TED & KAREN BENZON

POST FRAME BLDG FOR:

18130 TABLE ROCK RD.

ROOF FRAMING PLAN

**ROOF FRAMING PLAN**

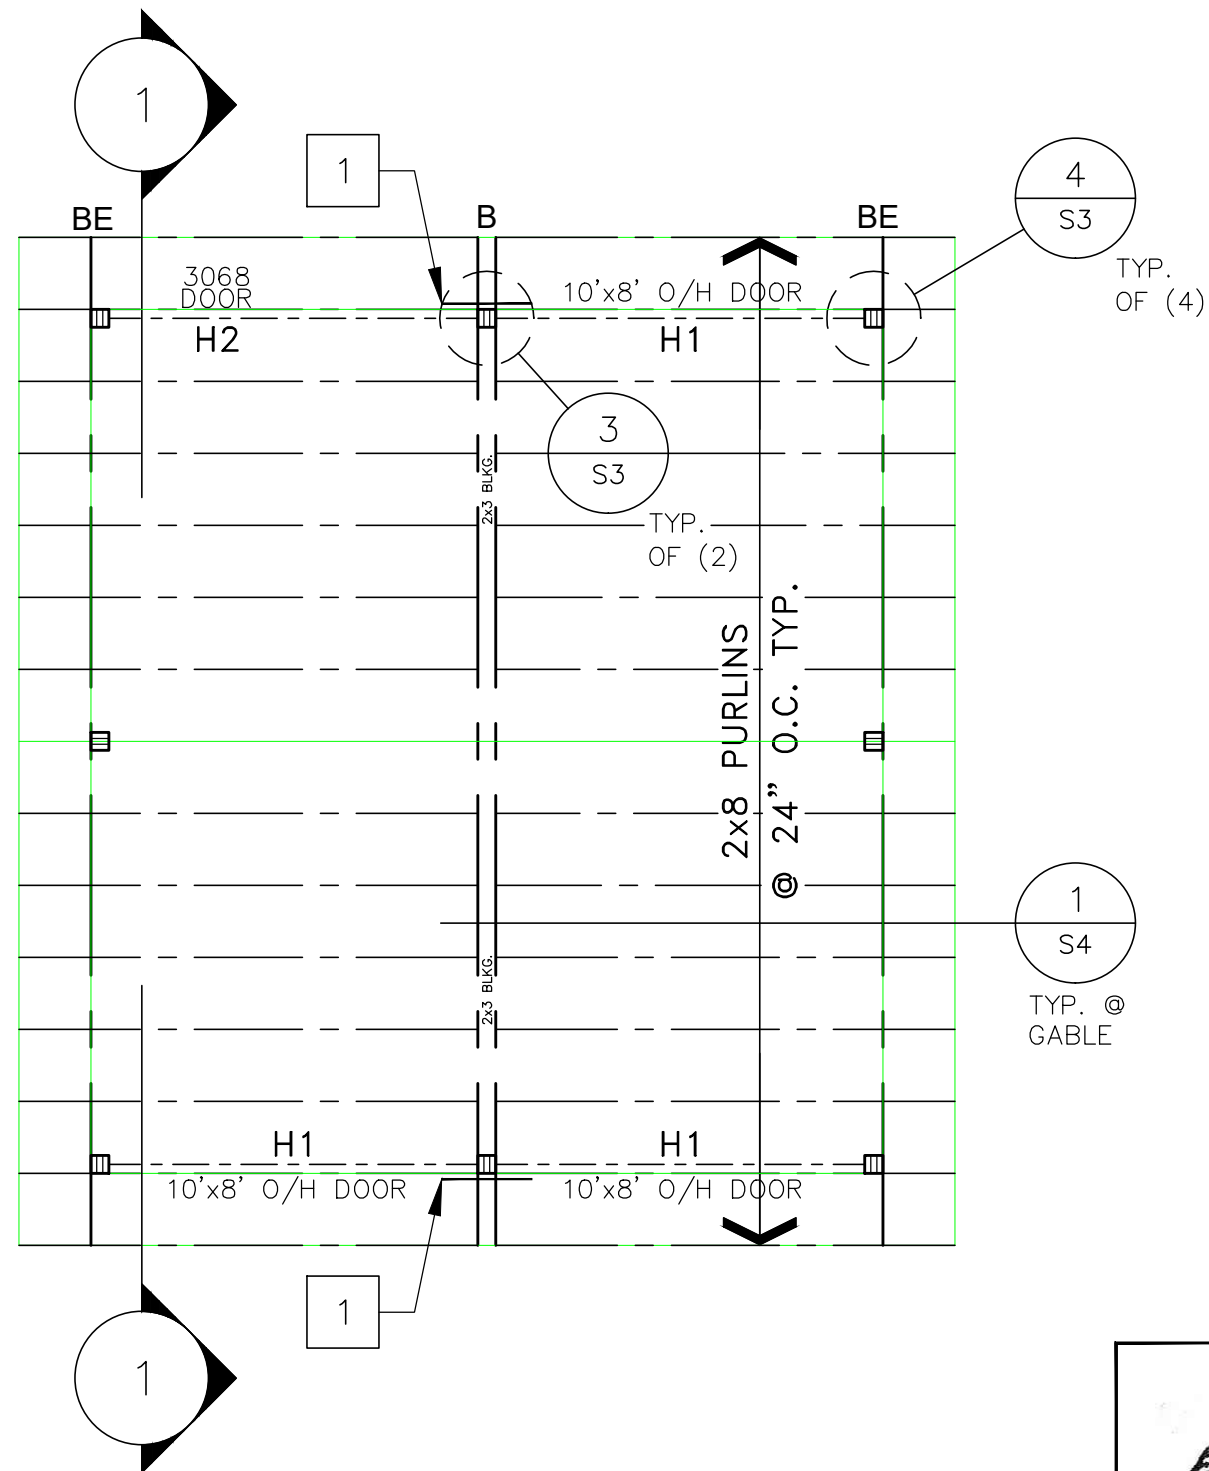
DISAPPROVED
 07/01/2020 8:40:22 AM
 bphillips
CONSTRUCTION
 Label trusses.
